Consultation Response from KC, Conservation & Design**2023/91236 & 2023/91237 - White Syke Farm, Marsden Lane, Marsden, Huddersfield, HD7 6AF****Erection of lean-to carport to western gable end (Listed Building)****Listed Building Consent for erection of lean-to car port to western gable end****Date Responded: 27.06.2023****Responding Officer: Sebastian Pickles****Responding Ref:**

White Syke Farm- Site Plan-Proposed Car Port  
(showing location of water course).

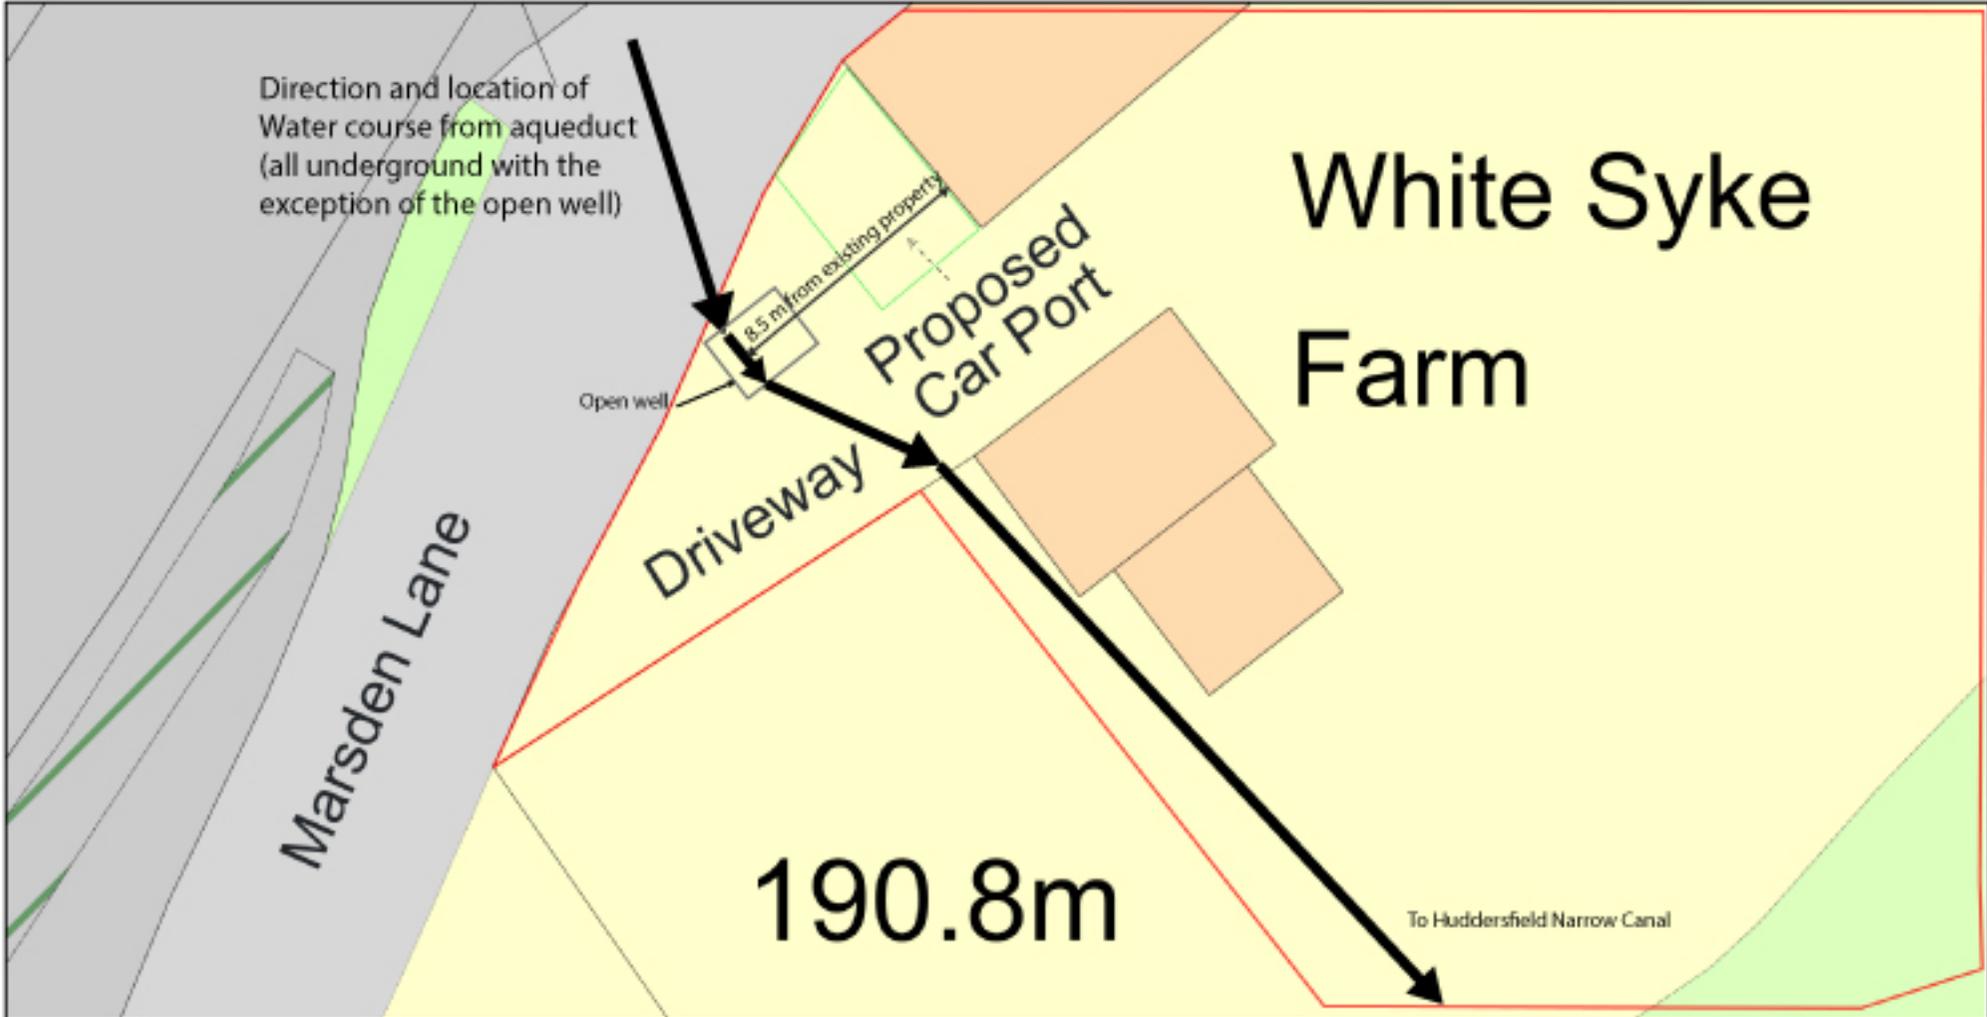
The proposed structure would be of a lean-to construction, with the main frame constructed using oak posts. This would essentially be an open structure. To the side furthest from the building the plans show a stepped dwarf wall, which is noted as being a retaining garden wall. There is limited detail for the materials and finish of the wall. We would ask for further detail to be provided for the stepped wall, so as to ensure the detail is acceptable. We consider that it would be appropriate for this to be a drystone wall to tie in with the vernacular and character of the site.

The roof is stated as being constructed in timber shingles. We understand the rationale behind this in terms of keeping the structure lightweight, however, we are not convinced that this will blend with the character and setting of the building. We are of the view that the roof should be finished in natural stone slates to match the roof of the host Farmhouse and attached Barn.

Overall, Conservation considers that the proposed carport will have a degree of impact on the setting of the listed farmhouse. The structure would be visible on the approach along Marsden Lane. However, given the nature of the structure and its more lightweight and open form, we consider the structure could be acceptable. This is however subject to the additional detail for the stepped dwarf wall and amendments to the roof finish, as set out in the main comments.
